**From:** Contact Centre (CRM) <contact@ribblevalley.gov.uk>  
**Sent:** 02 October 2023 11:13  
**To:** Planning  
**Subject:** Planning Application Comments - 3/2023/0529 FS-Case-551228396

**Planning Application Reference No.:** 3/2023/0529

**Address of Development:** The Bayley Arms Hotel  
Avenue Road  
BB7 9QB

Item B1. 1no. Set of sprayed foamex letters. Lit by floodlight.
(see CSI 006 K F for fixing details)

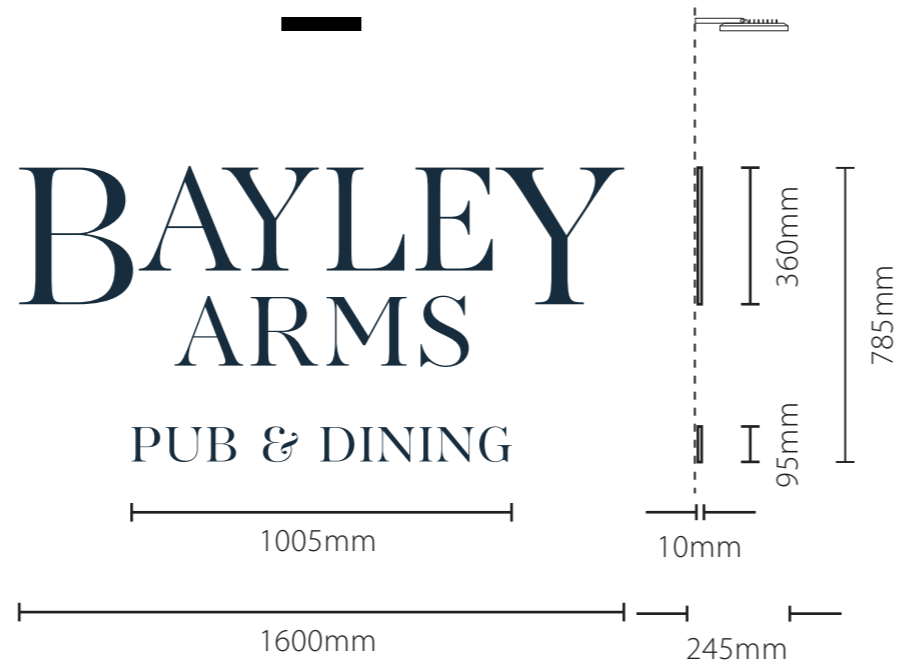
**Comments:** [REDACTED] The Bayley. Previously we have been troubled by light pollution at night by a floodlight on The Bayley, similar to those being suggested on the planning application. There is currently one floodlight on the south wall of The Bayley which has bothered us at night. The previous occupant kindly positioned it such that it didn't shine out into the village [REDACTED] as much, but it is still far too bright for its position & role. Given that there are already street lamps in the area & that it is small village, a residential area where people's bedrooms are near-by, and that there are many bats in the area, I would like to ask that dimmer lighting be specified (45000 lumens is very bright - unnecessarily so & will cause too much light pollution). 50w / 4000 lumen bulbs would be better suited when our eyes are dark adapted, preventing glare & creating fewer deep shadows.

I would like to suggest that the lighting scheme:

A - uses significantly dimmer lights more suitable for the job (4000 lumens max not 45000)

B - ensures lights are angled carefully, to prevent light pollution to neighbouring homes

C- includes colour specifications towards yellow/orange/red spectrum rather than white/blue which cause more disruption to wildlife
